Inspector's Report ACP-324045-26

PROTECTED STRUCTURE: Whether the removal of the internal partition wall between two units, for the purpose of amalgamating the units into a singular unit is or is not `development and is or is not 'exempted development', whether the change of use from Restaurant to Retail is or is not `development and is or is not 'exempted development' and whether works to the shopfront is or is not `development and is or is not 'exempted development'.

59-61 Dame Street, Dublin 2

0533/25

Figure 4.2: Existing Ground Floor Plan after Internal Works Carried out

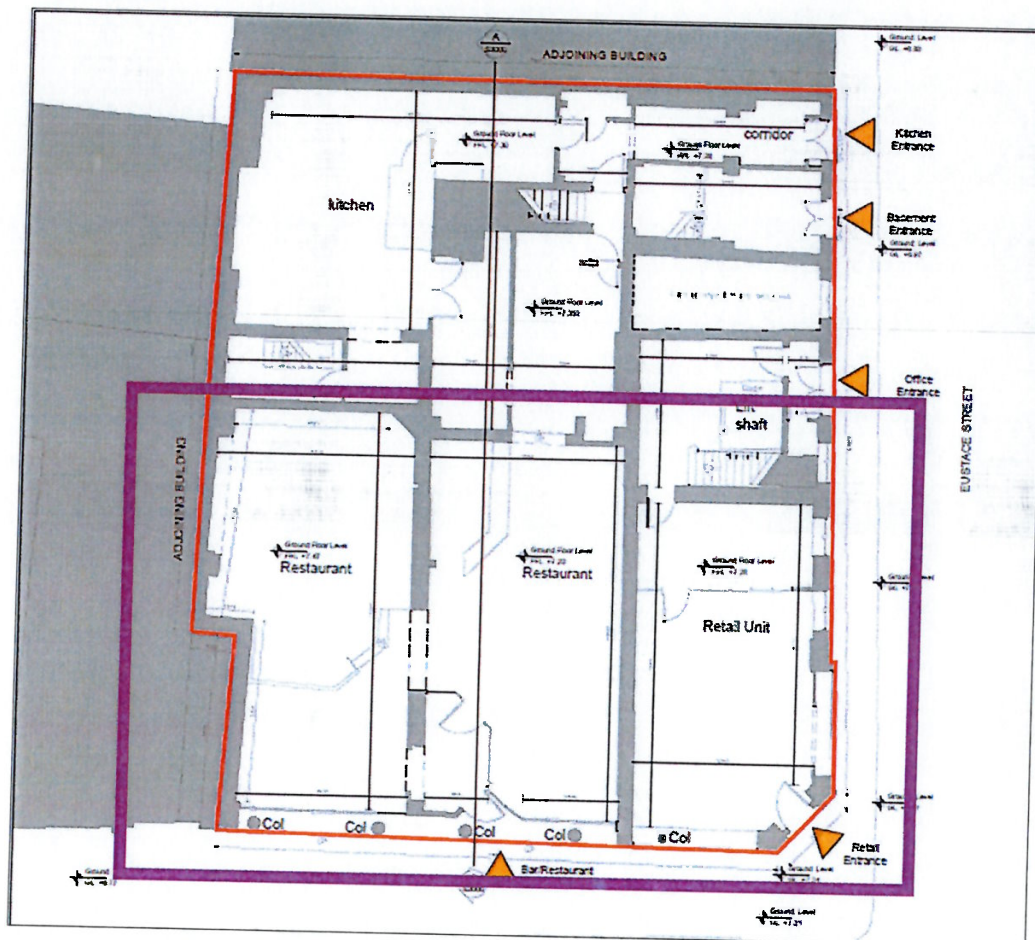
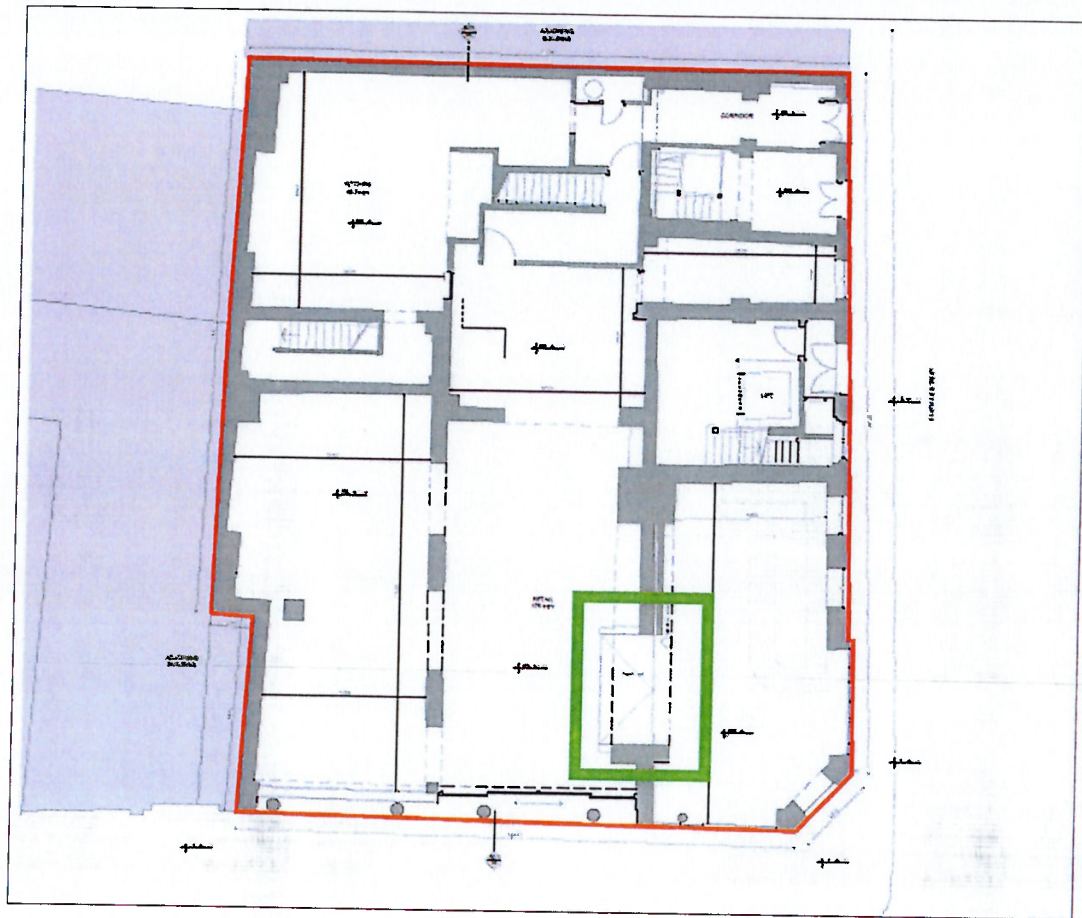
- 8.2.1. Removal of Internal Walls: The first question to consider is whether or not the removal of a section of the internal wall (approx. 3m wide) for the purpose of amalgamating units No. 59 and 60-61, Dame Street, is or is not exempted development. The referrer has regarded the proposed internal alteration works to fall under the exemptions stated under Section 4 (1) (h) of the 2000 Act. The Planning Authority in their assessment considered the works to be not exempt as it would materially alter the character of a protected structure.

- 8.2.4. The amalgamation of units has resulted in a much larger unit that extends across Units 59-61, permanently altering the urban grain along the street and rendering it inconsistent with its original character. If similar amalgamation of units is allowed under exempt regulations, this would alter the form of retailing along city centre shopping streets that would in turn impact the proper planning and sustainable development of the area. The works thereby do not fall under the scope of exempt
